From: Jim Henn
Sent: 15 August 2012 15:31
To: Planningecons
Subject: RE: Planning Consultation on: FP/153/12/

APPLICATION NO: FP/153/12/

Site Address: 43 Downview Road Felpham PO22 8HH

Description of Works: Front and rear extensions

Project: Proposed alterations; Little Thatch, Downview Road, Felpham PO22 8HH	
Drawing: Elevations as proposed	
For: Mr. R. Taft	
Drawn: PKS	Date: July 2012
Scales: 1:100	No: 960/01/05
To scale when printed on A3

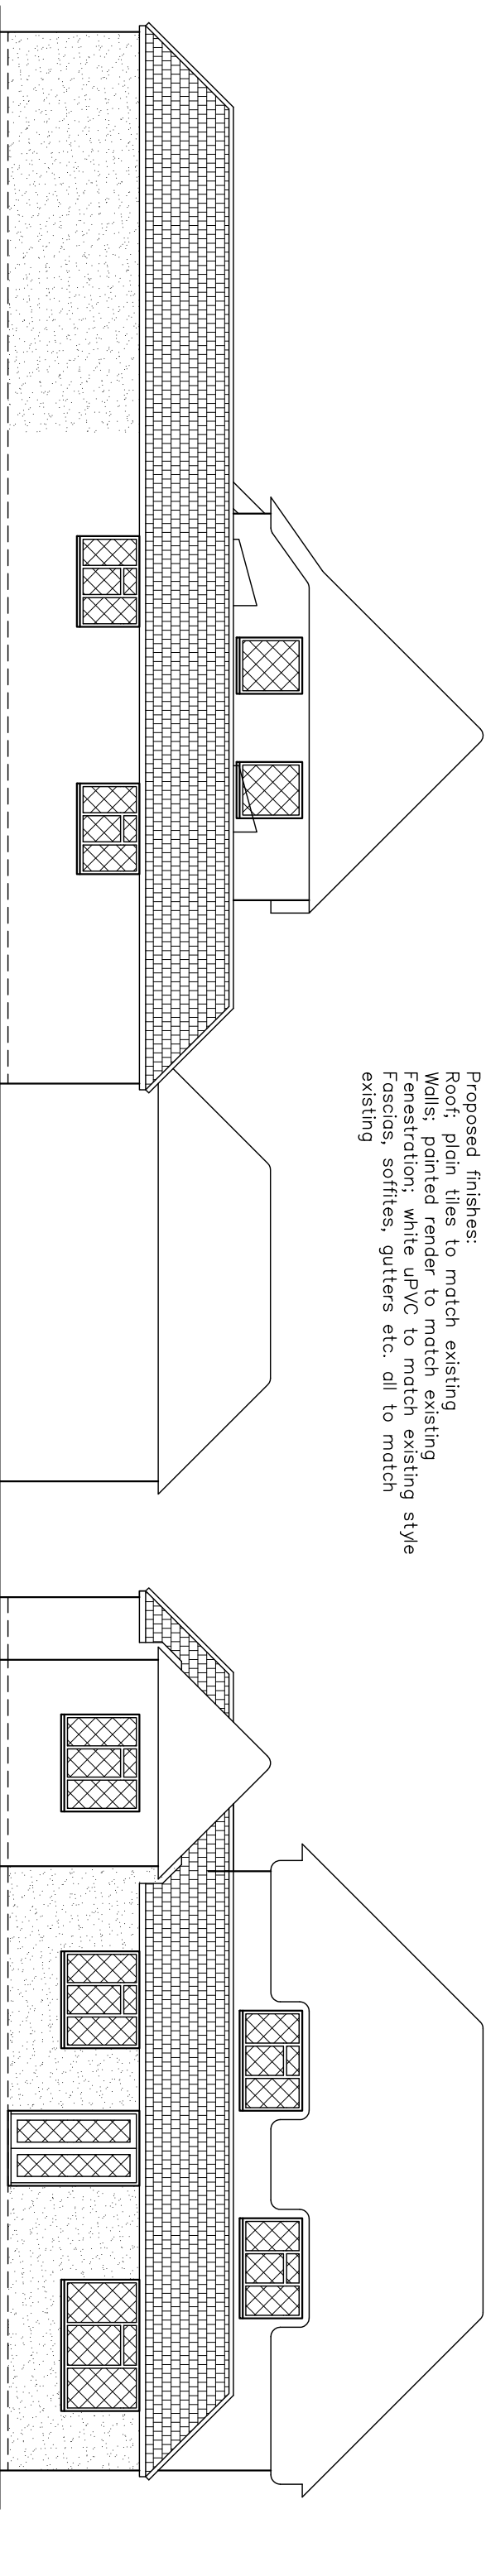
- The existing building has a thatched roof.
- However, it appears that the new extensions are to have tiled roofs
- The Building Control issue of new thatched roofs and external fire spread is not relevant in this particular case.
